The Former Ship Inn, Aldwick Street, Bognor
Proposed One Stop Store
Applicants Response to Stage 1/2 Road Safety Audit For One Stop Stores

Applicants Response to Stage 1/2 Road Safety Audit For One Stop Stores

Drawing No:
B 102

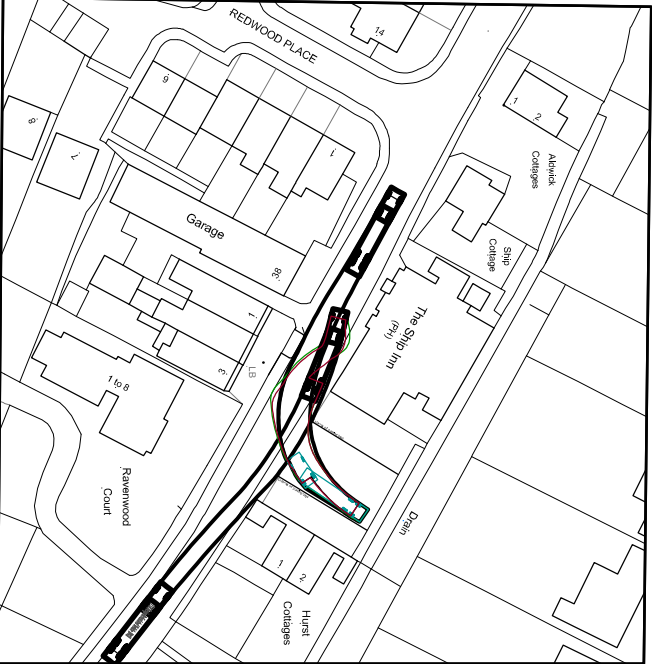
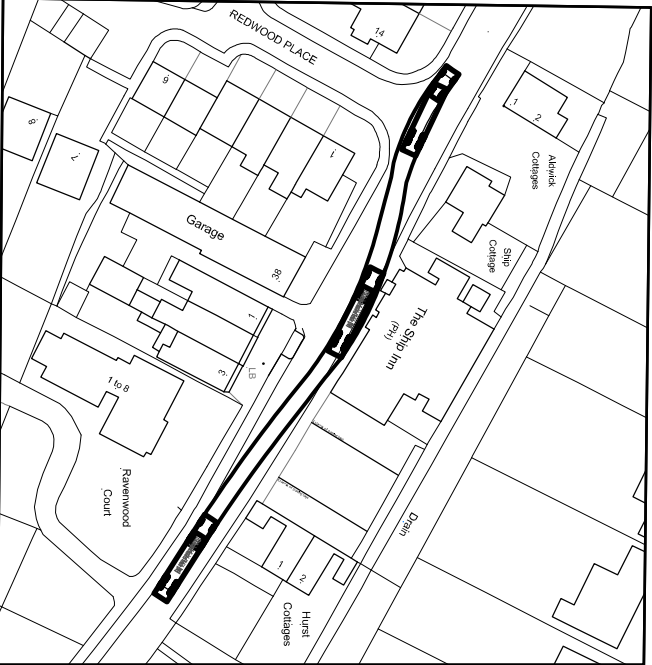
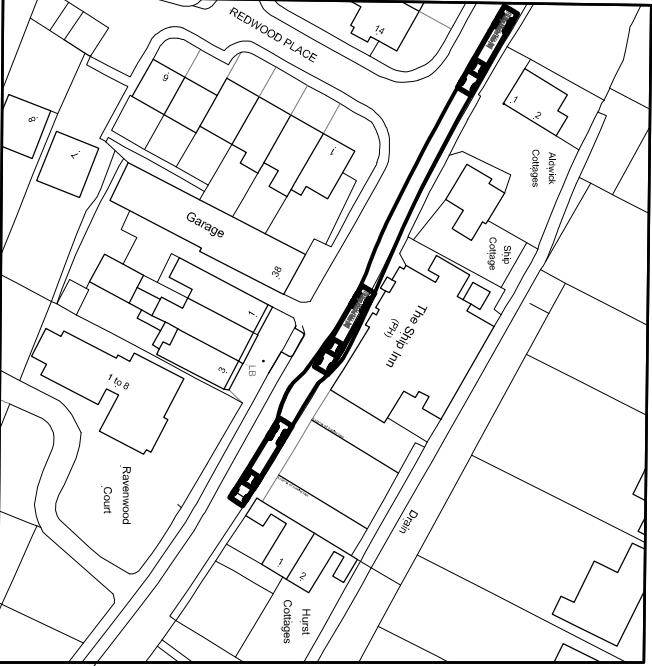
5.3	Carriageway widths and swept path should be sufficient for vehicles to manoeuvre.	With regard to the s.278 build-outs, have not been involved with the design of the proposals, which consider the carriageway widths and swept-path proposals of vehicles in general at the roadway. These designs were issued to WSCC for approval as part of the s.278, and carriageway widths can be reviewed as part of that application. However, in terms of the delivery vehicles, reference is to be made to the swept path tracking plans issued as part of this application, which form an integral part of the proposals, and are an integral part of the Planning Permission. One should note that there is sufficient space for vehicles to pass the delivery vehicle when adjacent to the building.

Client
One Stop Stores Limited
Project
The Former Ship Inn, Aldwick Street, Bognor Regis. PO21 3AP
Title
Site Location Plan with Vehicle Tracking : Articulated Vehicle
Scale
1:500 @ A1
Date
07.01.2020
Drawn By
PAL
Checked By
PM
Project No:
B190031
Drawing No:
B 202
Revision
A

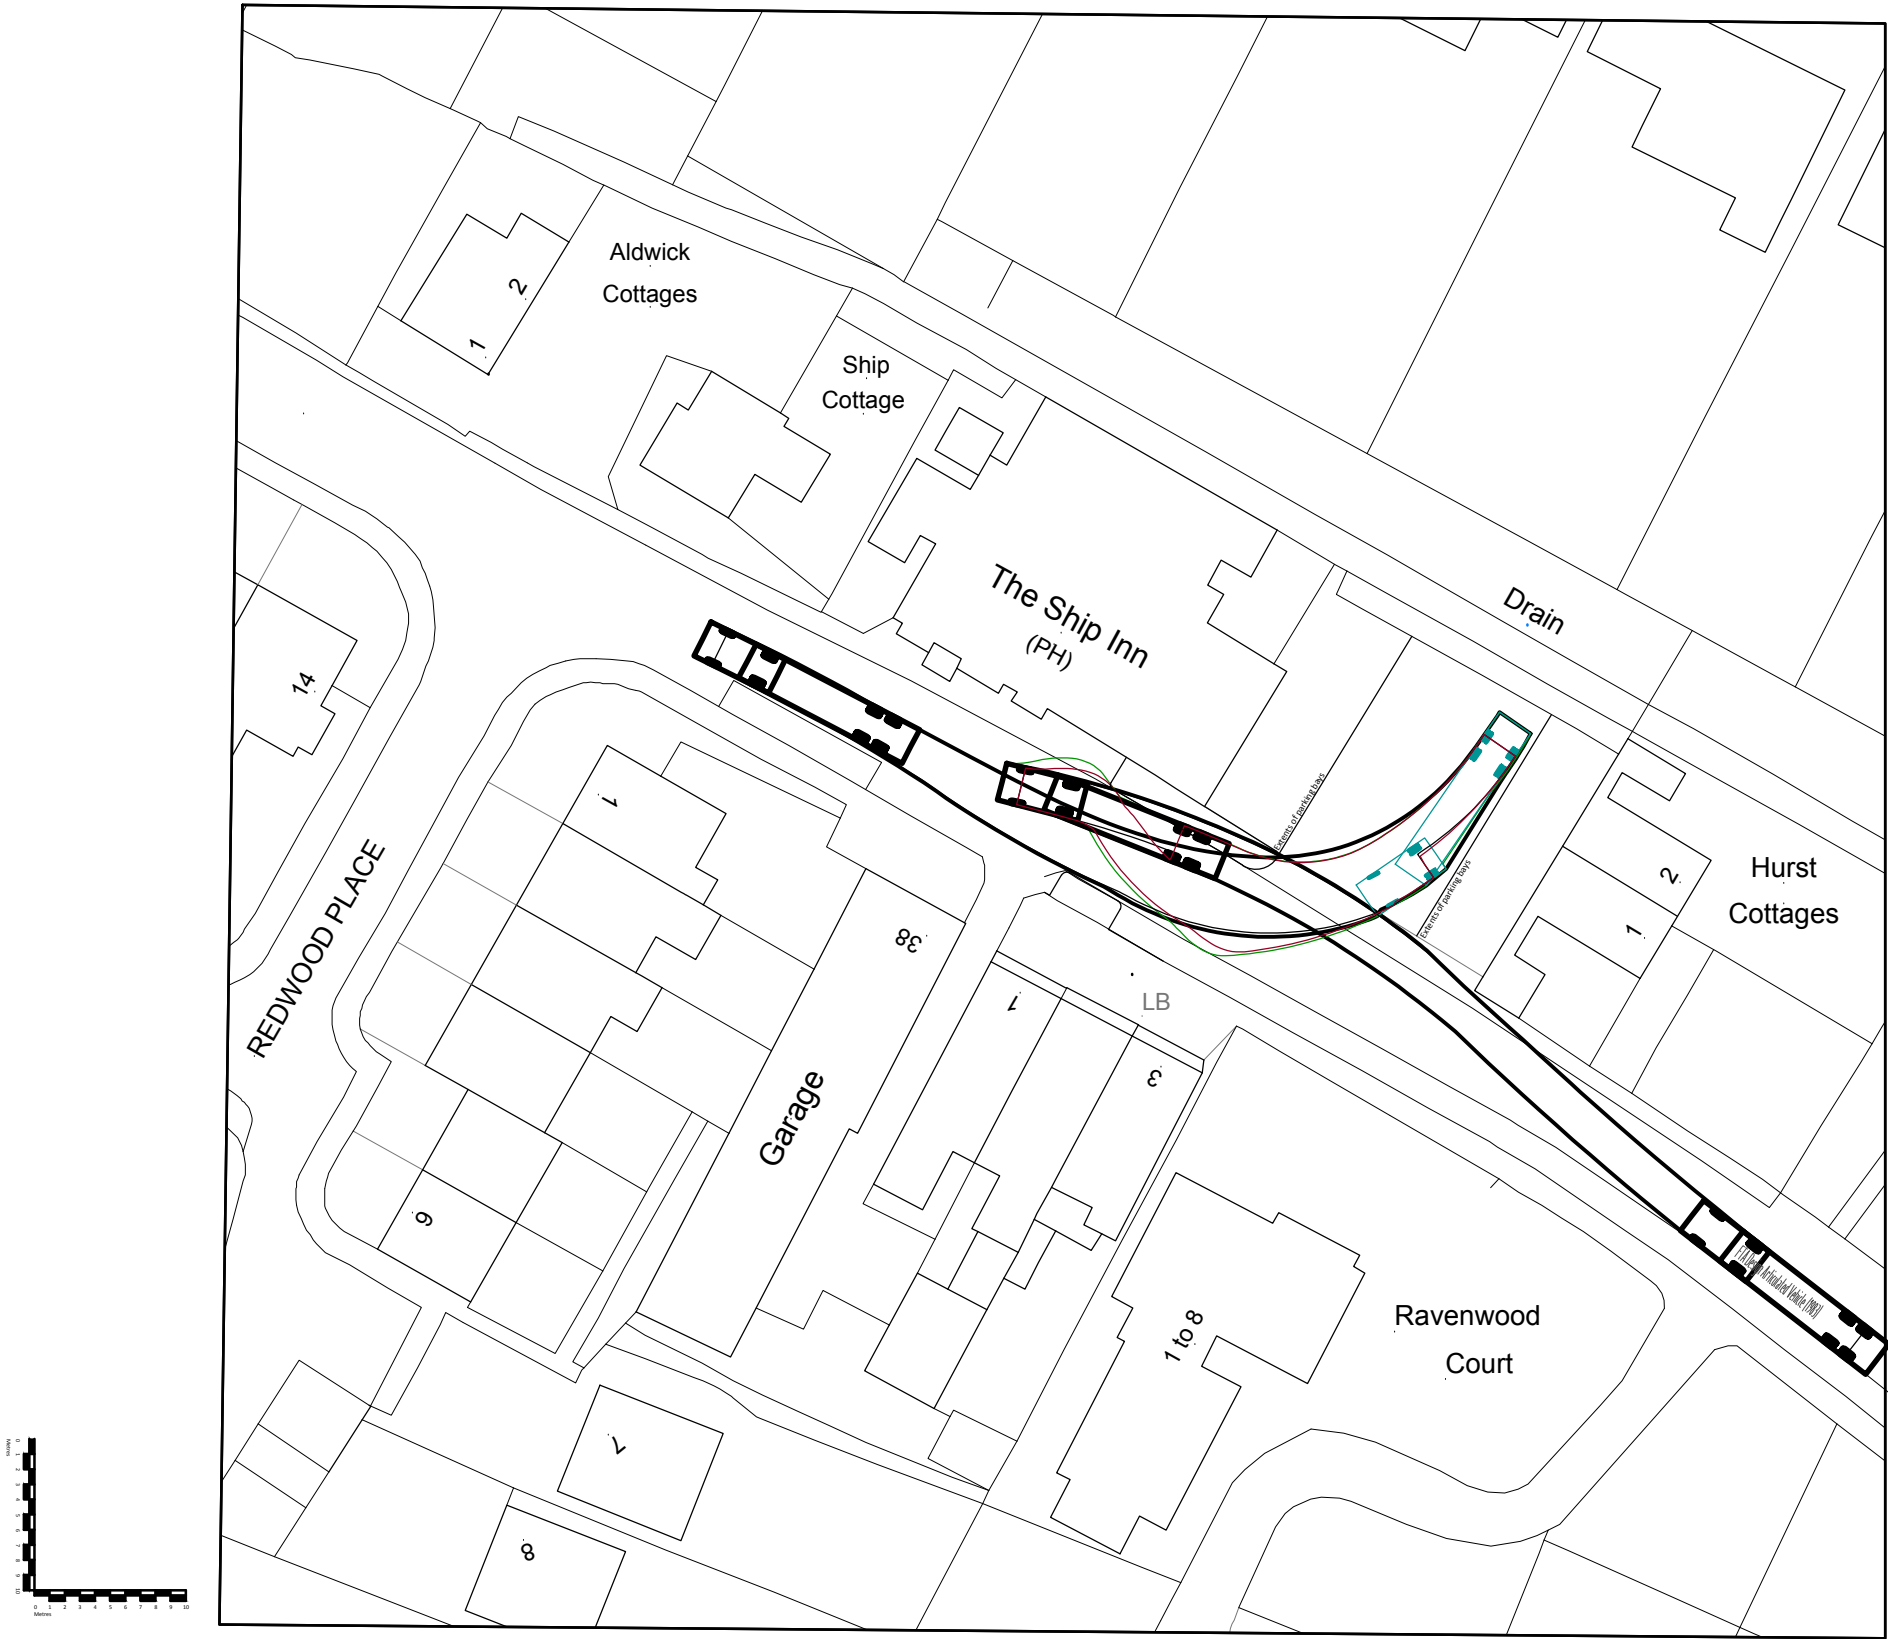
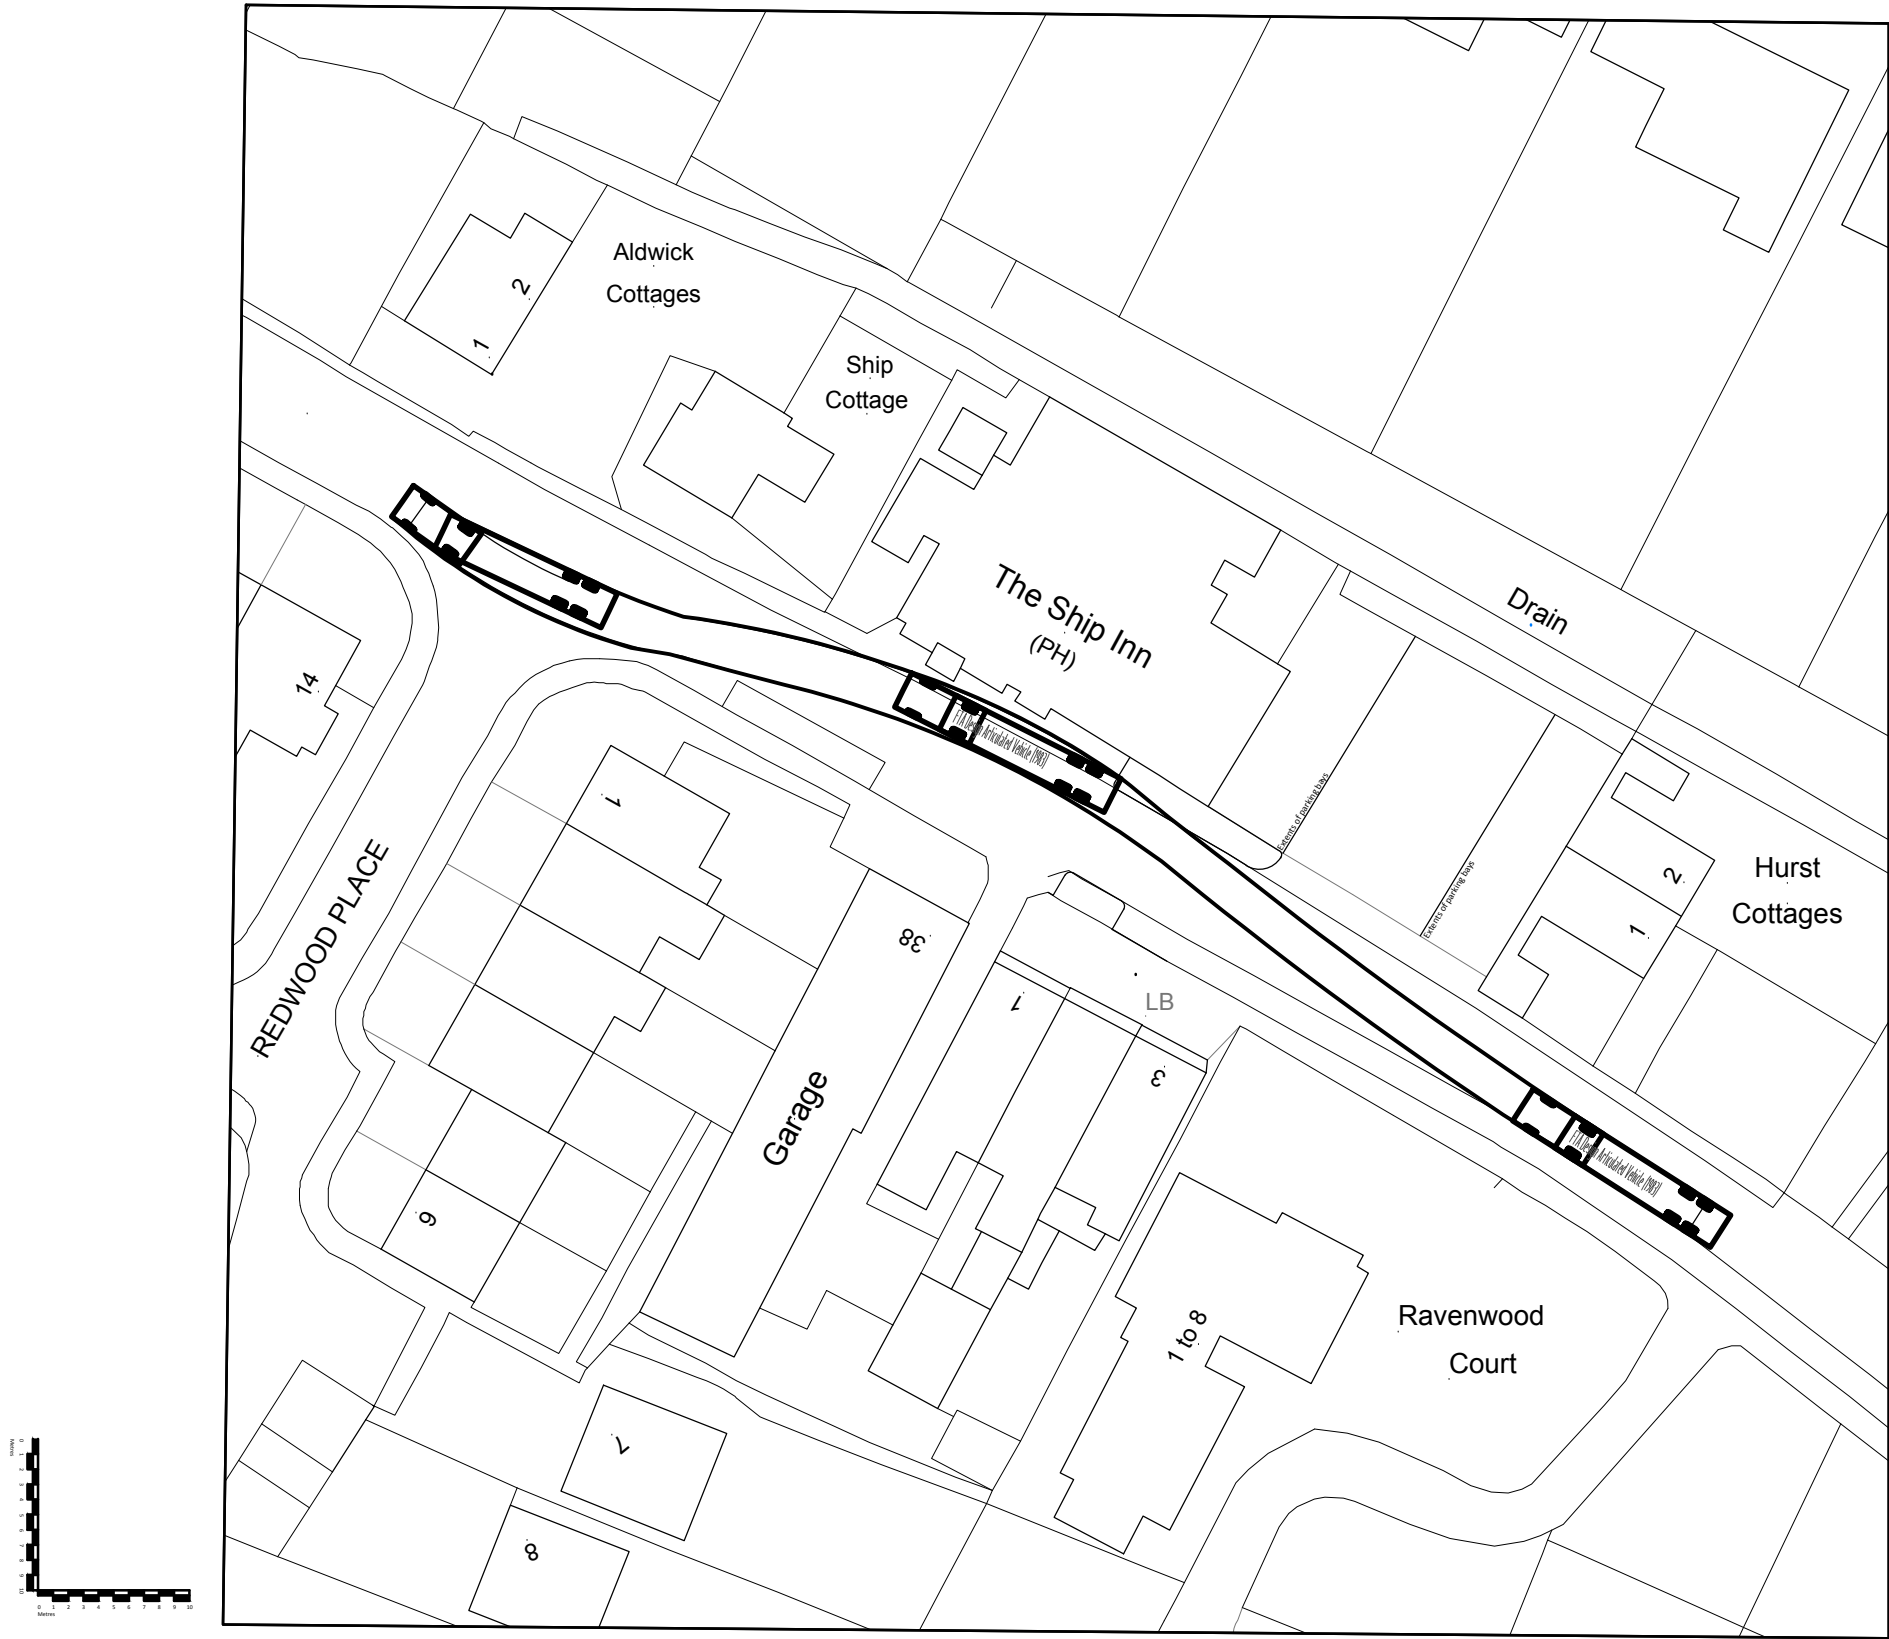
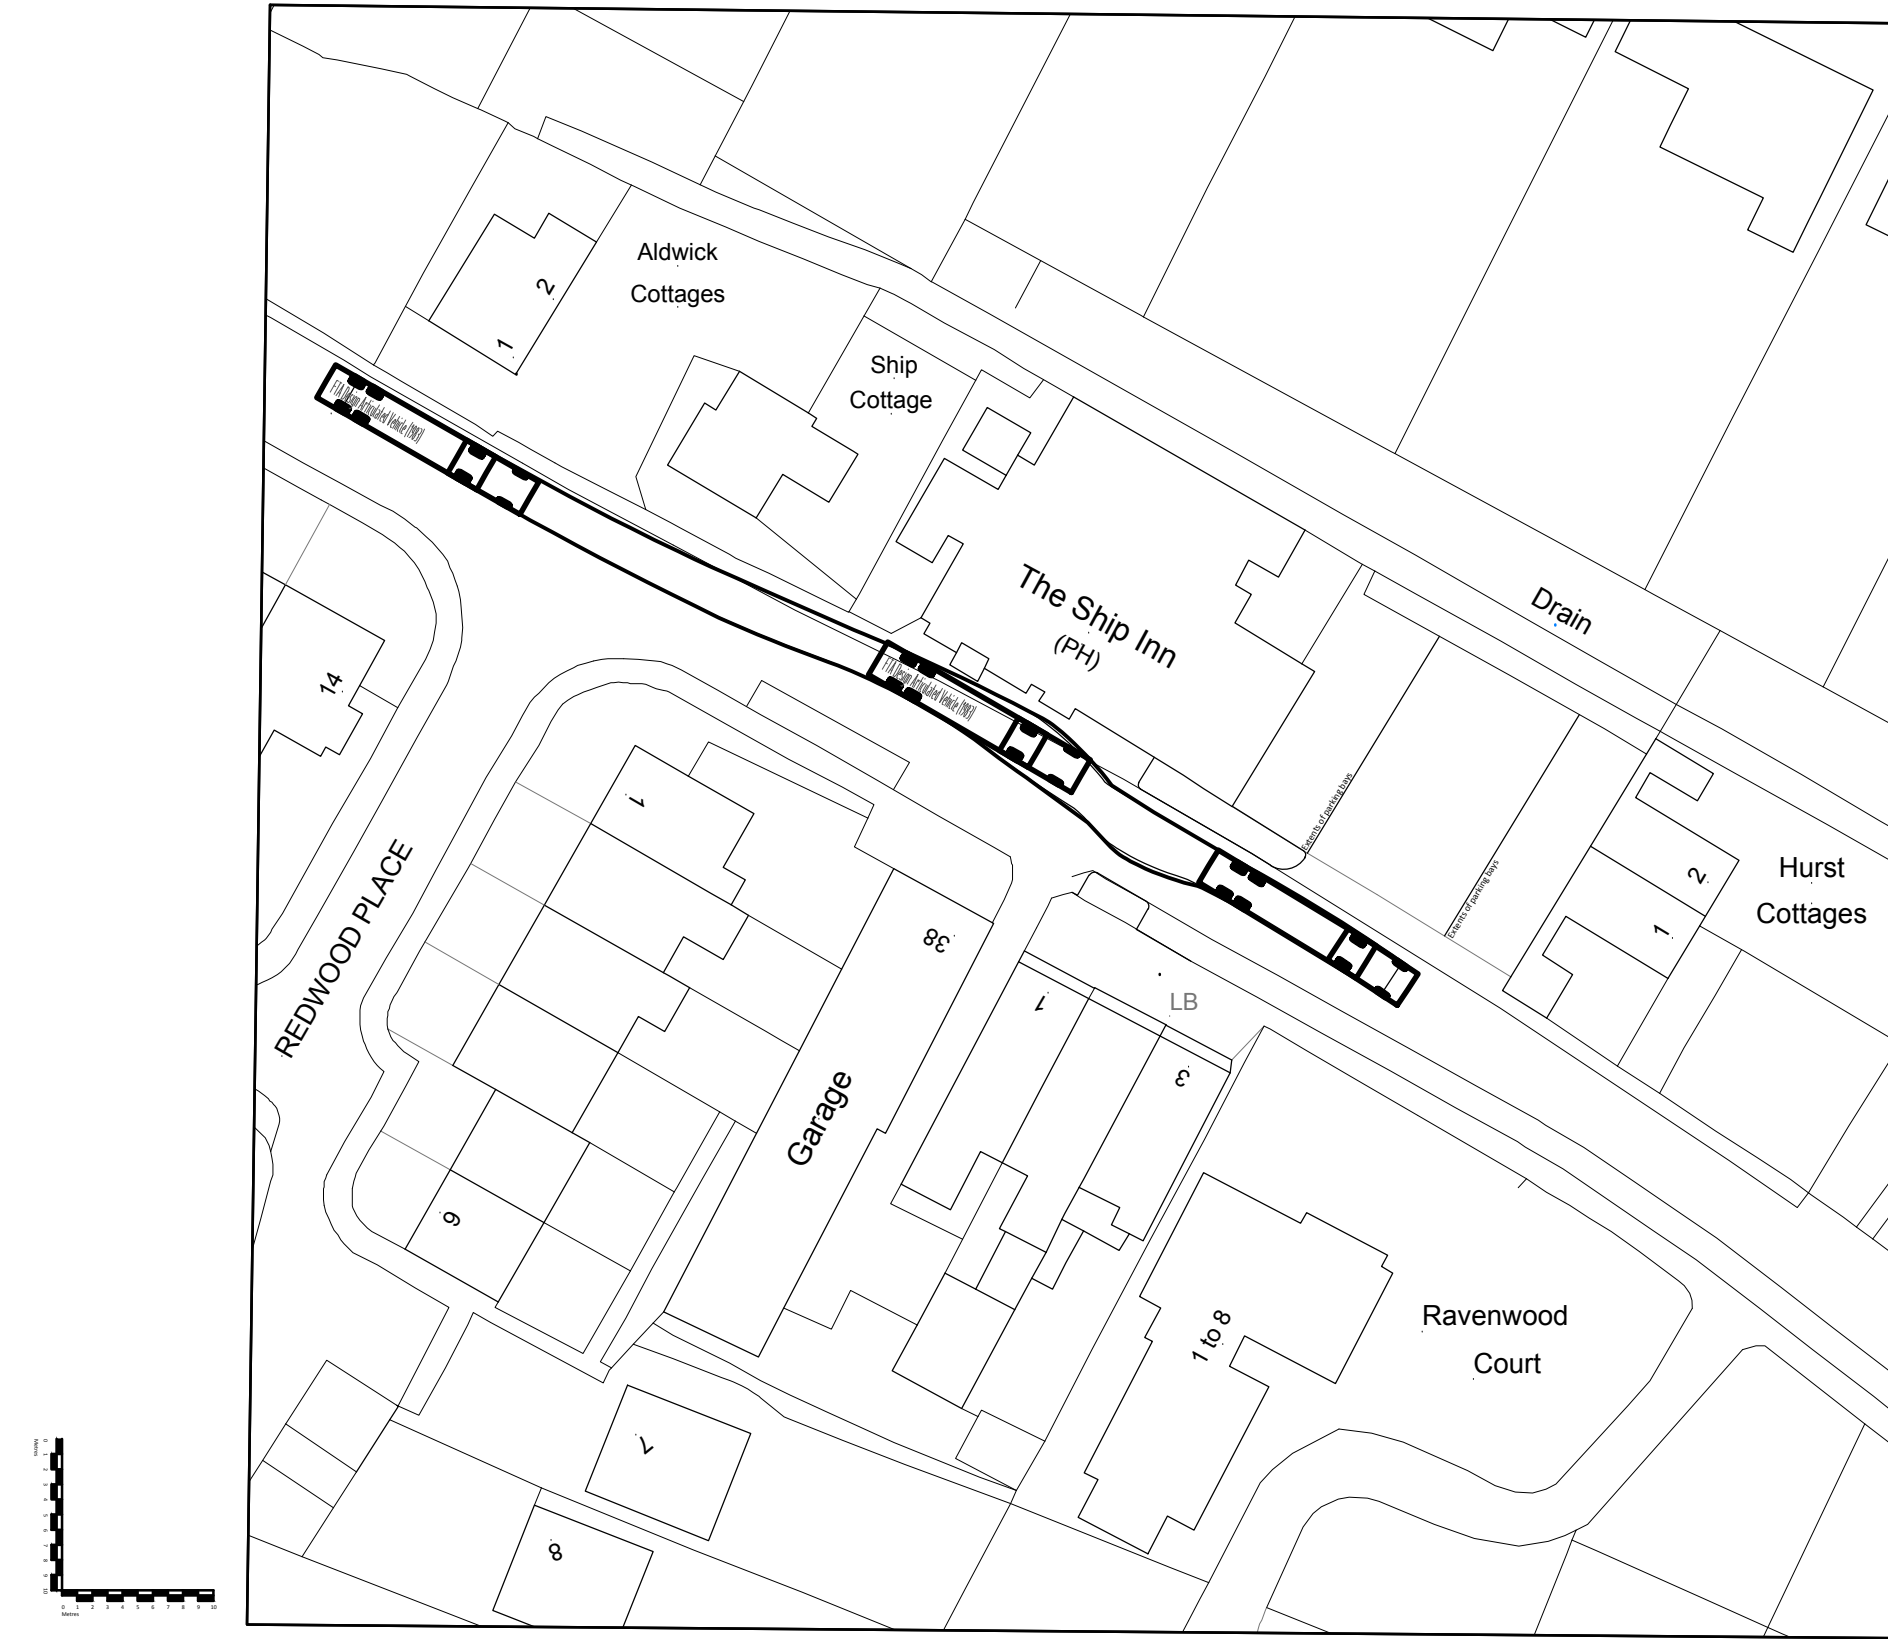
Item No.	Audit Team Recommendations	Applicants Response
5.1	Carriageway levels should be reviewed and drainage provided at the proposed buildouts as necessary.	We have not been involved with the design of the build out proposals. These designs have been previously issued to WSCC, and subsequently approved as the desired construction details in agreement with WSCC as part of the s.278. If additional further drainage is deemed necessary, then by agreement with WSCC, a drainage channel could be incorporated to maintain the kerbside drainage channel continuity, unless another reasonable solution can be suggested, if needed or warranted by WSCC. However, it is reiterated that these details are previously approved.

Item No.	Audit Team Recommendations	Applicants Response
5.5	Pedestrian routes approaching the store should be formalised.	A pedestrian crossing point to the highway will be provided as part of the s.278 proposals. This is with the build-out, which is shown on all tracking plan drawings.
5.6	No issues raised.	n/a
